**SSD-53386706 Mod 2 – Bank Street Park – Advice on Modification**

Thank you for your correspondence dated 25 November 2025 inviting the City of Sydney (the City) to comment on the above referenced State Significant Development application. The City has reviewed the application and **objects** to the changes in the proposed modification as outlined below.

DRAWING TITLE  
**LIGHTING DESIGN  
 LIGHTING LAYOUT - SHEET 02**

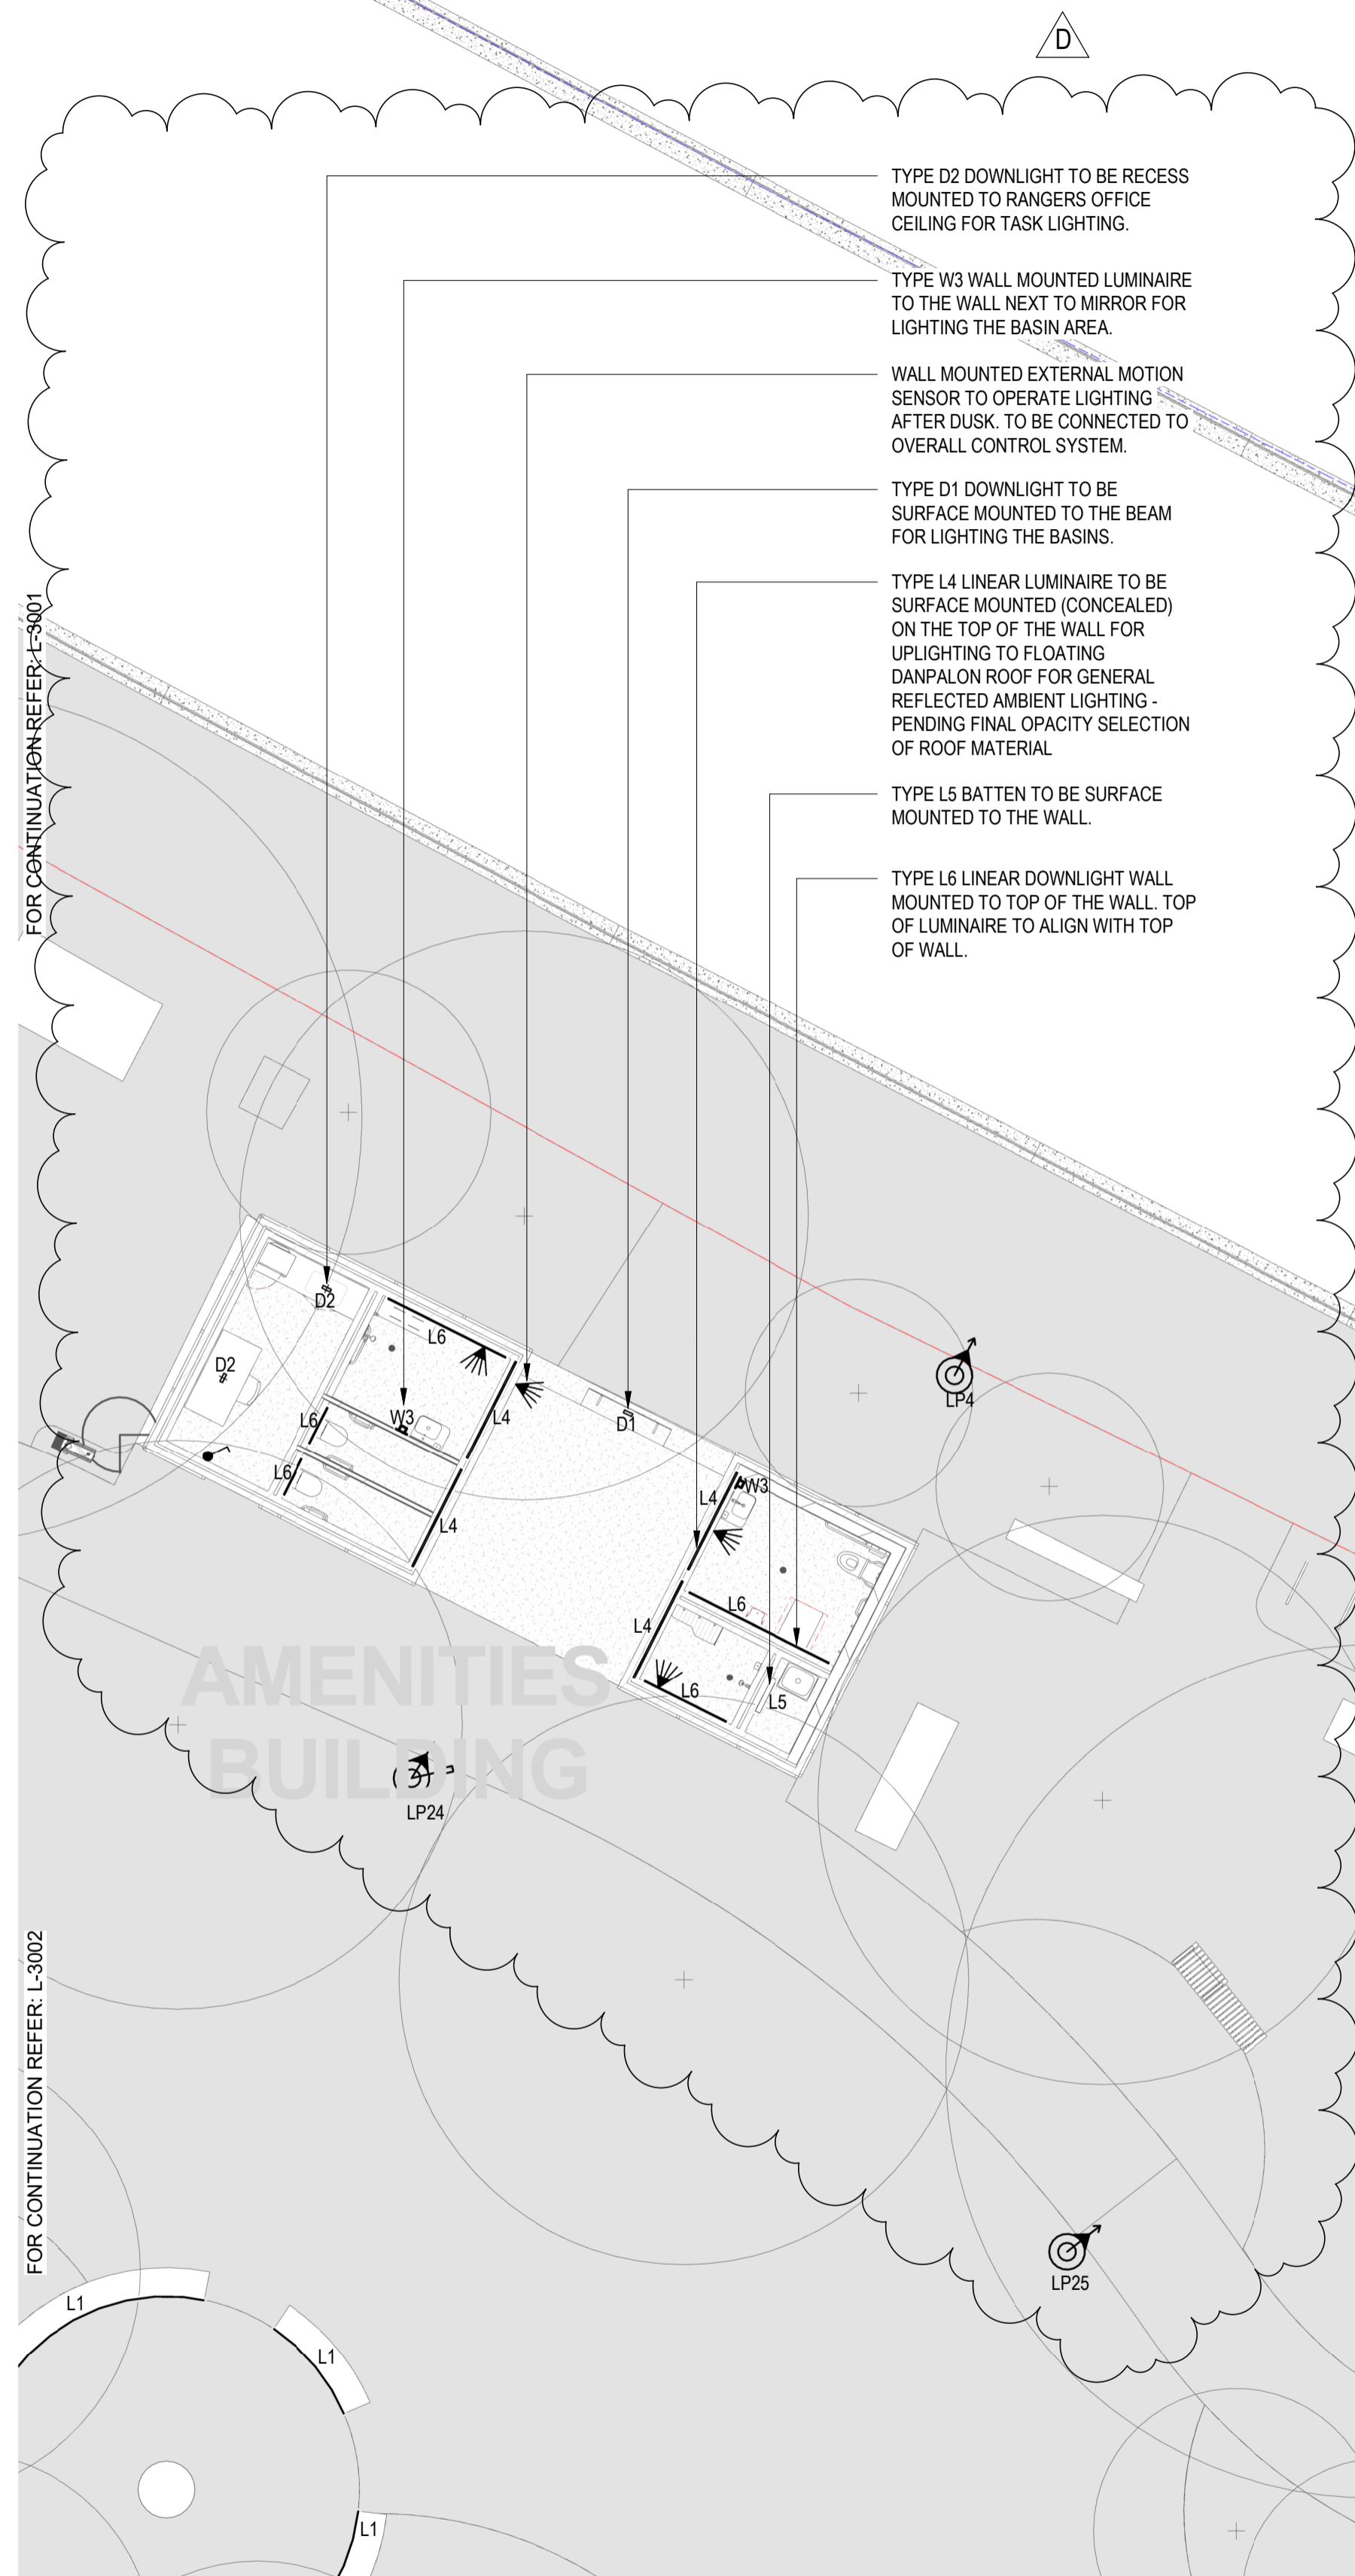
The City objects to the deletion of the approved community and amenities building and relocation of these core functions to inferior locations and buildings.

The retention of the existing amenities building is a poor outcome for the park. The facilities were originally constructed as a temporary measure to accommodate the relocation of Dragon Boating activities to Bank Street and is poorer quality than the approved amenities would be.

Additionally, this also results in the removal of a significant areas of landscaping located outside the shadow of Anzac Bridge that would have supported significant canopy tree planting. The City has made a number of submissions in the past advocating for additional tree canopy on site, particularly acknowledging the impact caused by Anzac bridge overhead, and objects any further diminishment of the approved tree canopy.

The retention of this building also takes away from the sense of openness, creating sight lines and inviting people into the park from the Bank Street shared path. This has also been reflected in the submitted security review which identifies a greater likelihood for break and enters or malicious damage. Overall, the review identifies that the proposed changes have a negative impact on the usership of the park and opportunities for passive and natural surveillance in comparison the originally approved building uses and layout.

The retention of marina facilities within a public park has been a point on contention for the community. Whilst the City acknowledges the role these facilities have in providing public and commercial access to the harbour, the approved building better allowed for the retention of these facilities with the smallest impact on the park by providing a small and well-integrated office area.

Instead, the proposed modification seeks to retain the existing temporary construction marina facilities, albeit in a relocated area, and takes up more space and is poorly integrated into the layout and design of the park. The space around the building is disjointed from the park whereas the approved building is a focal point and allows people to move around and through the building and enjoy the surrounding park areas, paths and landscaping.
